18/00825/HYBRID

Heyford Park, Camp Road, Upper Heyford

Drawing file: P16-0631_34Q Demolition-Change of Use Plan.pdf

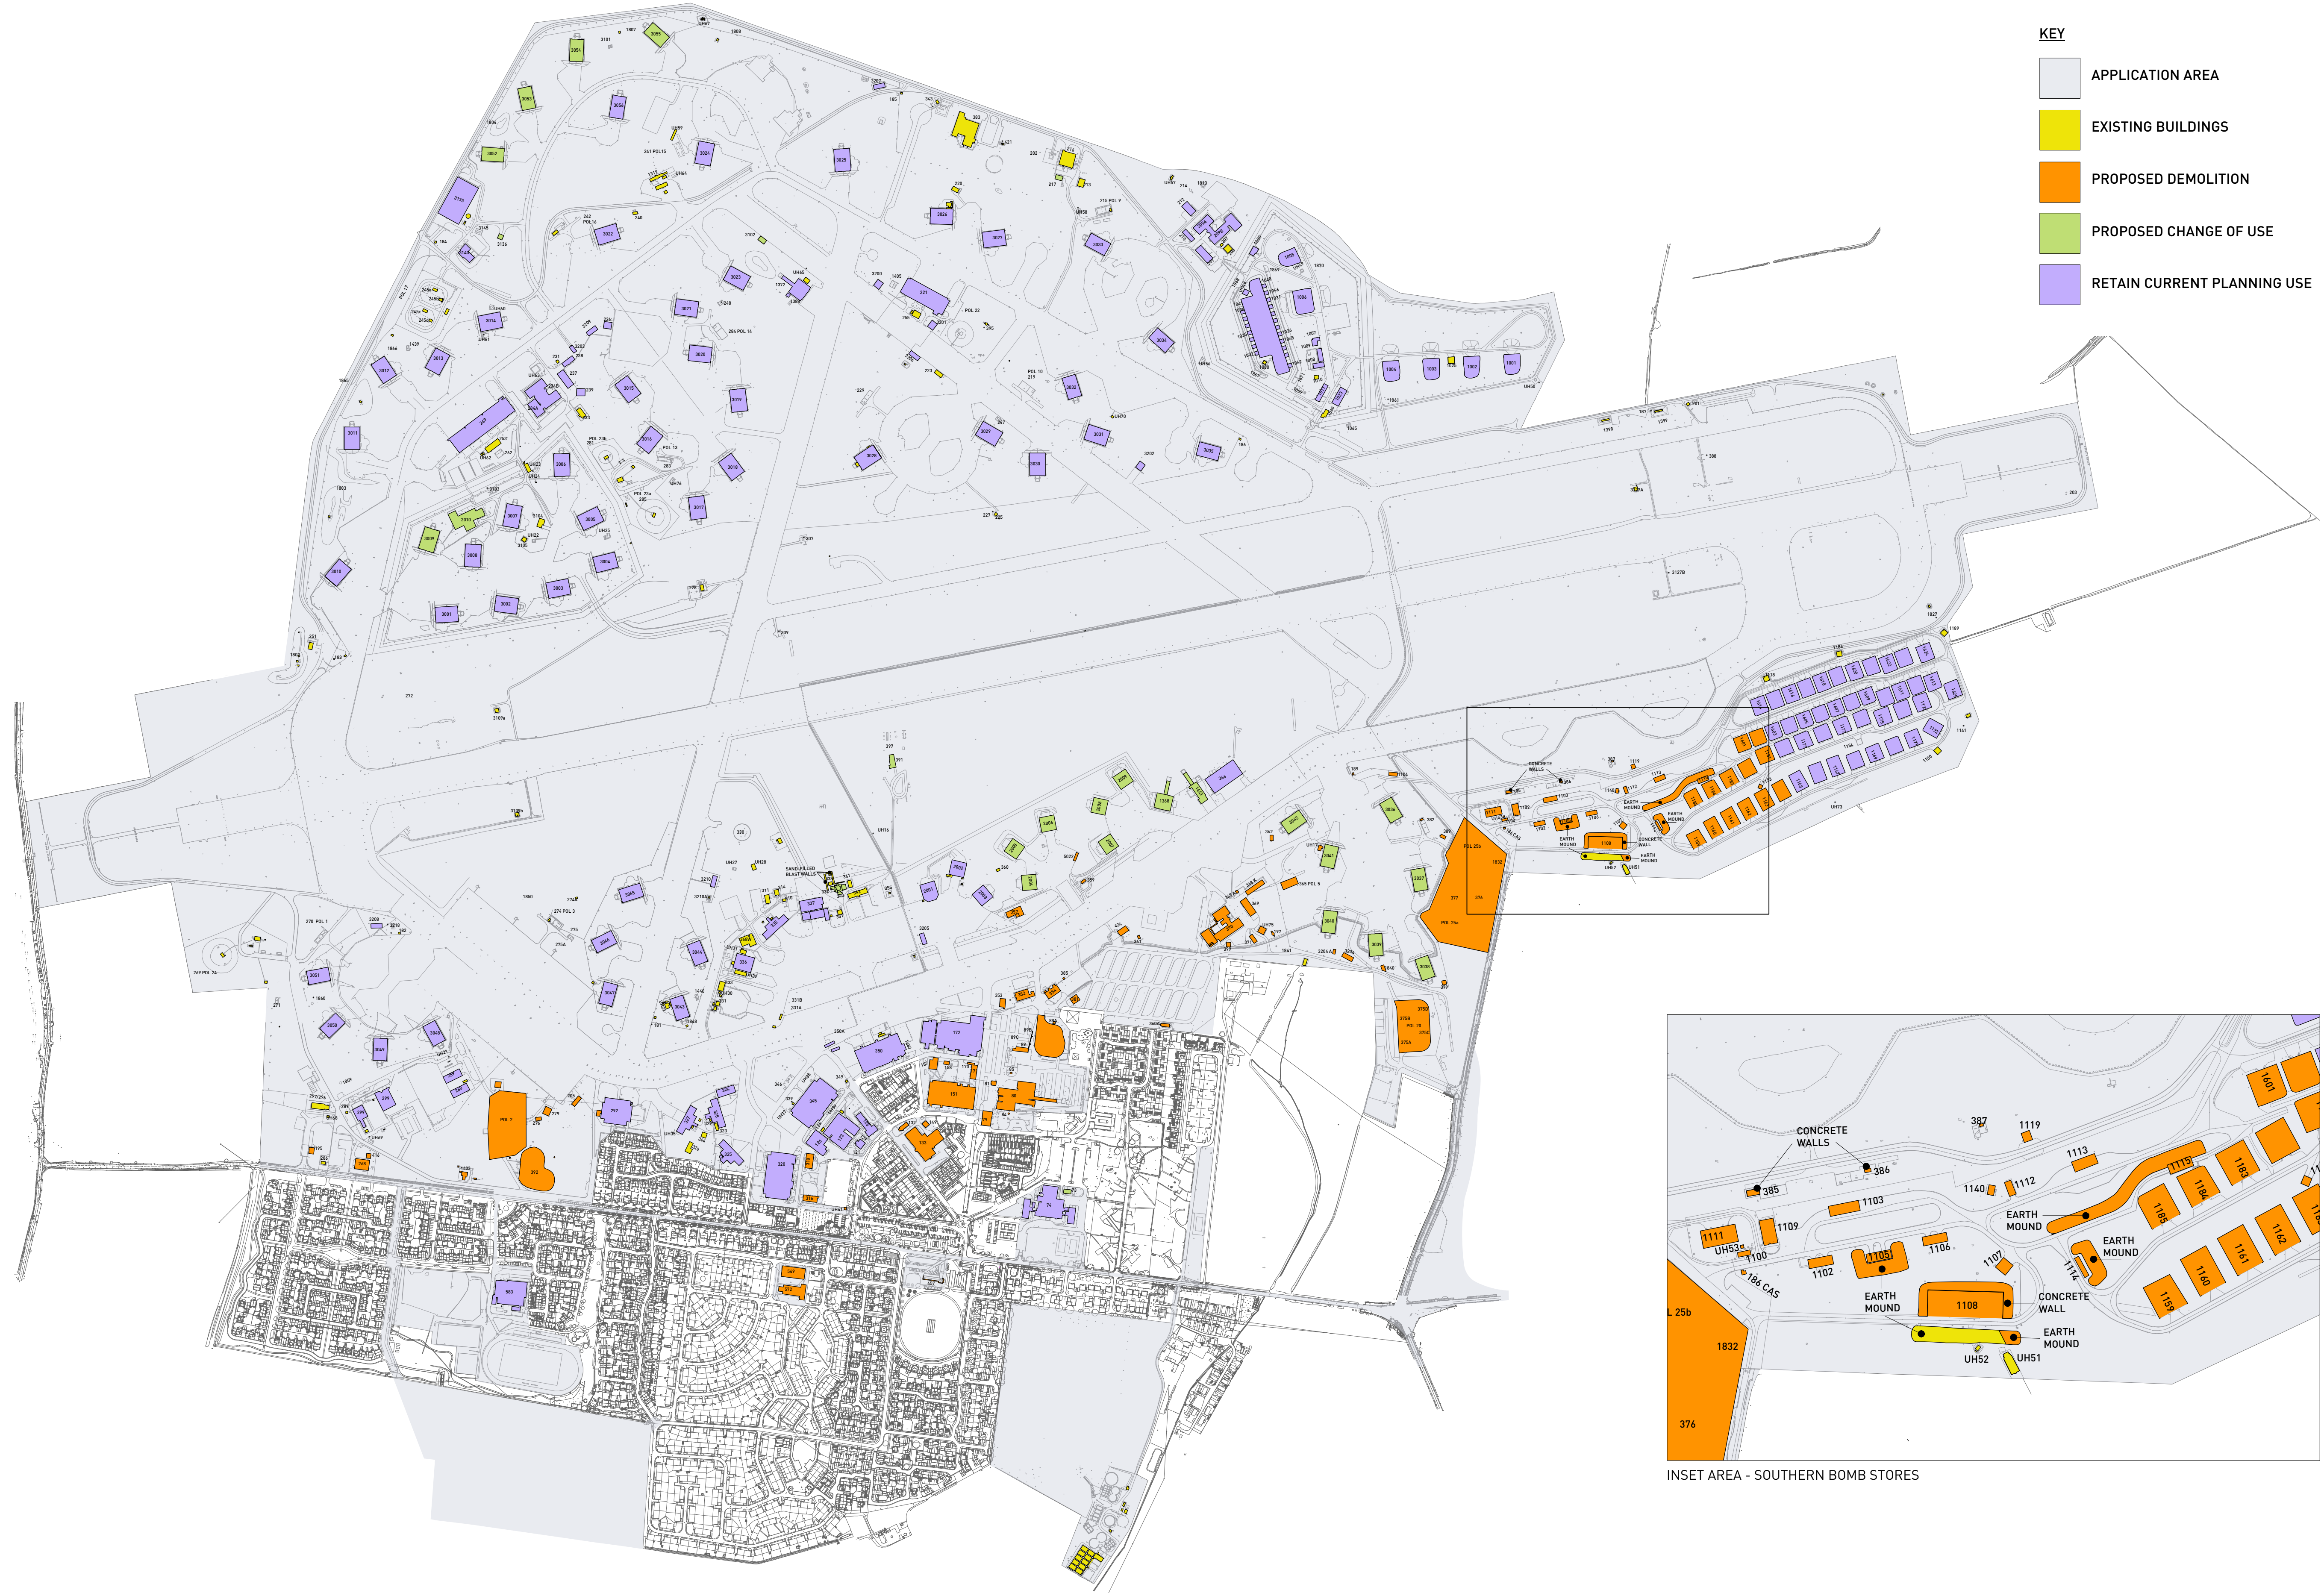
There are a large number of buildings proposed for demolition as part of the application as a whole. A Heritage Impact Assessment has been provided for some of these buildings. This is welcome, but there are concerns that there may be buildings of significance not covered by these HIAs.

Building 151 (an A Frame hangar) is proposed for demolition in order to provide space for creation of extra care units. It is appreciated that previously building 315 was also proposed for demolition and that this is now being retained.

We also commit that the new Heritage Centre in Building 1368 will be open to the public no less than 4 days a month and Dorchester will provide staffing to assist with this. However, it is likely that this will be increased as visitor numbers demand.

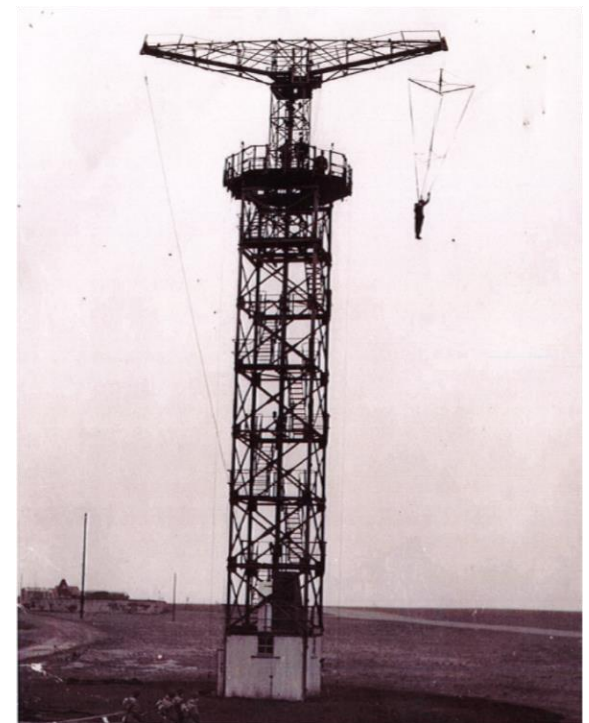
The buildings in this area include a former Hush House (building 1368), a former Engine Test Cell (building 1443) and five open sided aircraft hangars (buildings 2005-2009), which all lie within the Victor Alert area. The buildings are non-designed heritage assets and identified by the Heritage Impact Assessment as being of medium significance.

The open sided aircraft hangars are by their nature large, open spaces and are eminently convertible without losing their core significance. The key area of concern is to find suitable, sustainable uses for the buildings. The Design and Access Statement indicates potential uses for the buildings to include Heritage Centre, Exhibition Space, Science and Technology Hub (including code breaking escape room) and Adrenaline Park to include stake park, climbing wall and public seating area. There would be no objections to these uses.

HEYFORD PARK - FILMING ACCESS PLAN

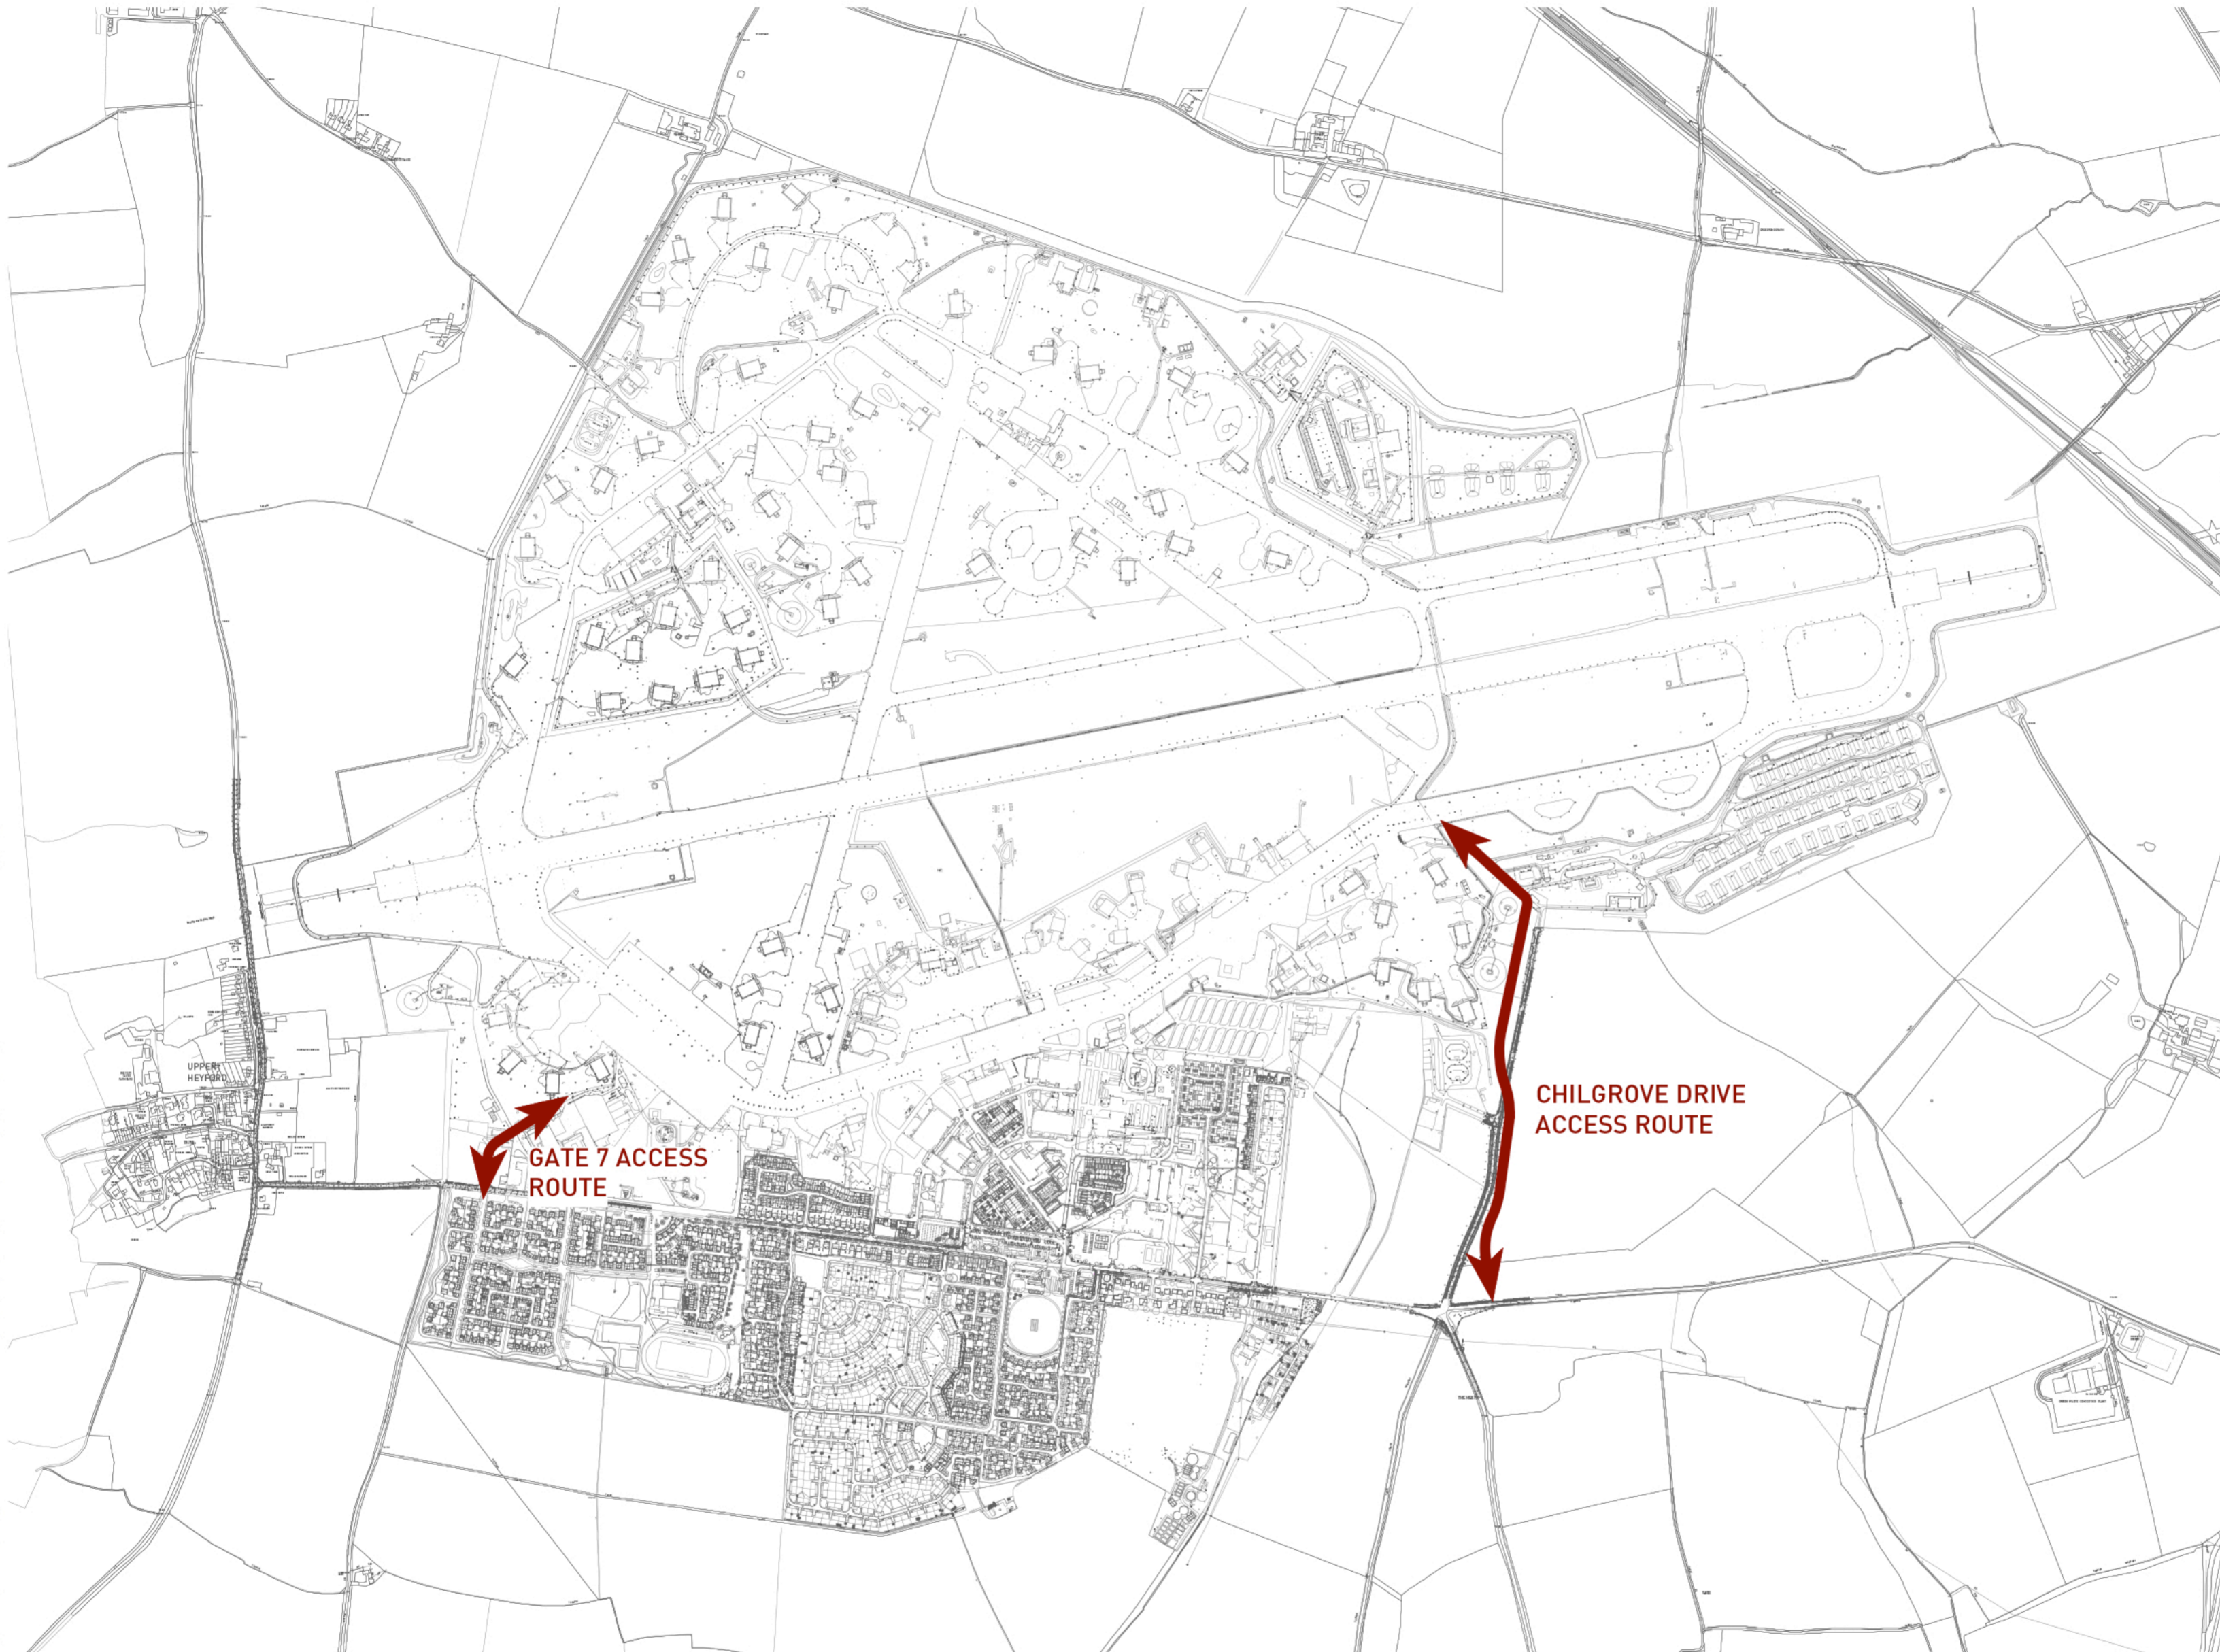
The proposal for filming on the airfield in the two separate areas identified on the masterplan is welcome. Filming has previously taken place on the site, based on limited timescales, although has never been formally authorised.

A form of management agreement will be required to ensure that filming activity on site does not damage historic fabric and this should be conditioned as part of the application. There are, however, concerns with the proposal to provide 'temporary set construction' along the taxiway. There is concern that any 'temporary' development in this location could become semi-permanent and would have a detrimental impact on the surrounding heritage assets. An alternative location in the hardstanding around the 'Creative City' Christmas Tree should be considered. If this element is absolutely essential to the viability of Creative City any temporary structures should be very tightly controlled by condition / management agreement which should relate to nature of construction as well as numbers of days per year. Consideration will also need to be given to the impact of floodlighting for filming.

Drawing file: Fig_18._Policy_map_for_Heyford_Park__v1.pdf

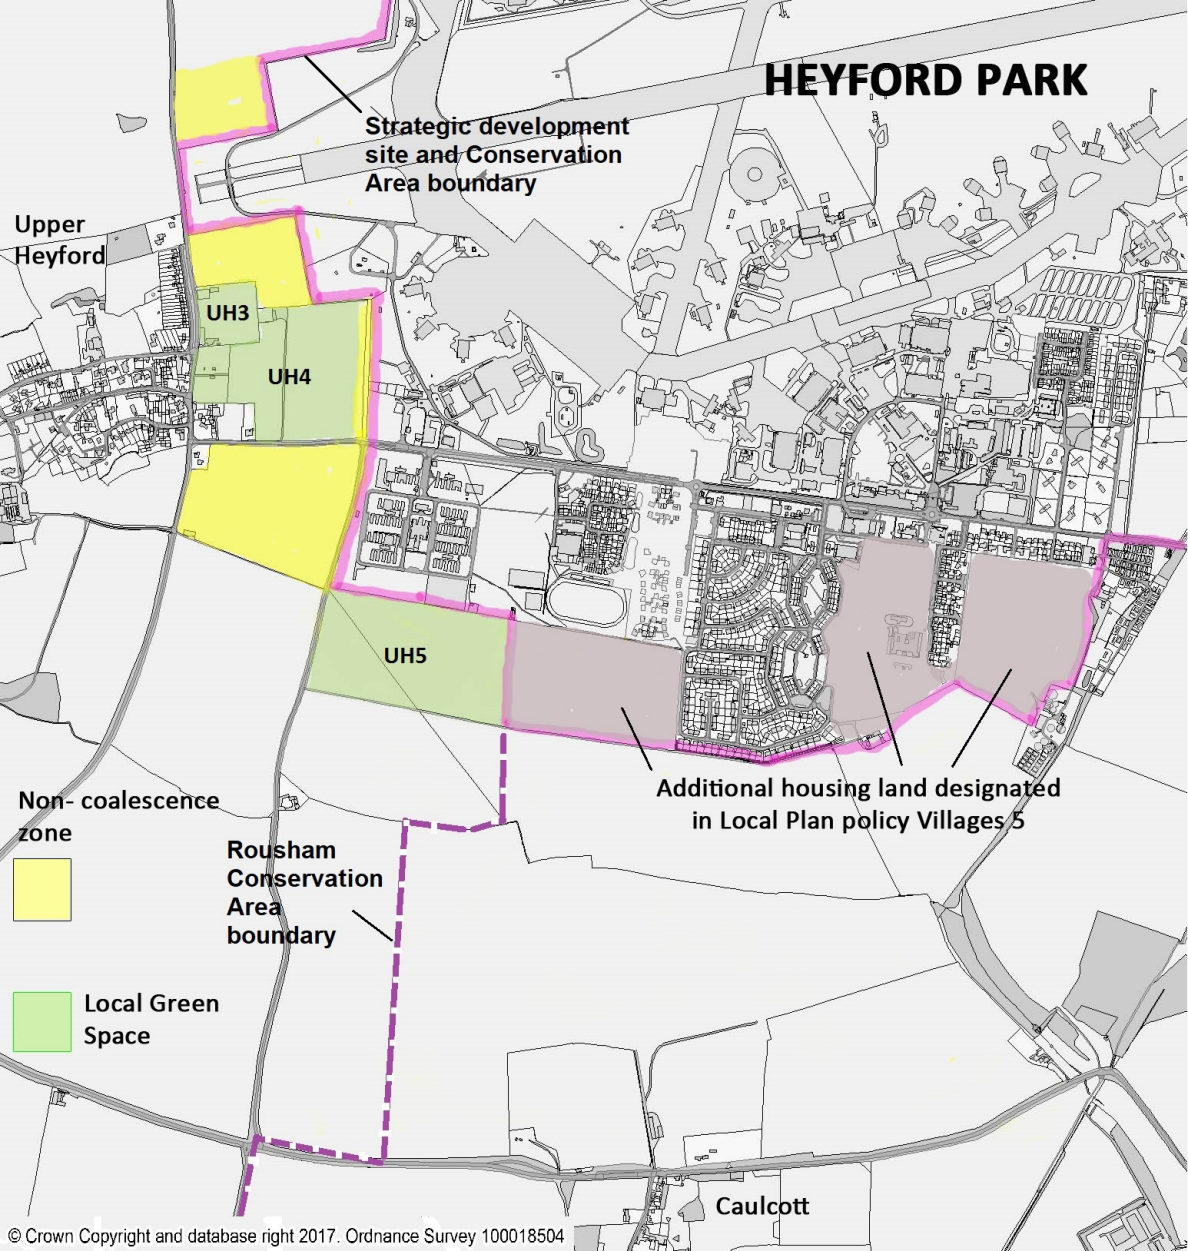
The Mid Cherwell Neighbourhood Local Plan includes Policy PD3 specifically on the Heyford base which states ' A zone of non-coalescence, defined on Policy Map Fig. 18, on the western boundary of Heyford Park shall prevent coalescence of any development proposals at Heyford Park with the

village of Upper Heyford..... Any development which is proposed adjacent to the designated strategic area of Heyford Park (as defined by Local Plan policy Villages 5) should not give rise to coalescence with surrounding settlements, to ensure that their separate identity and character are maintained.
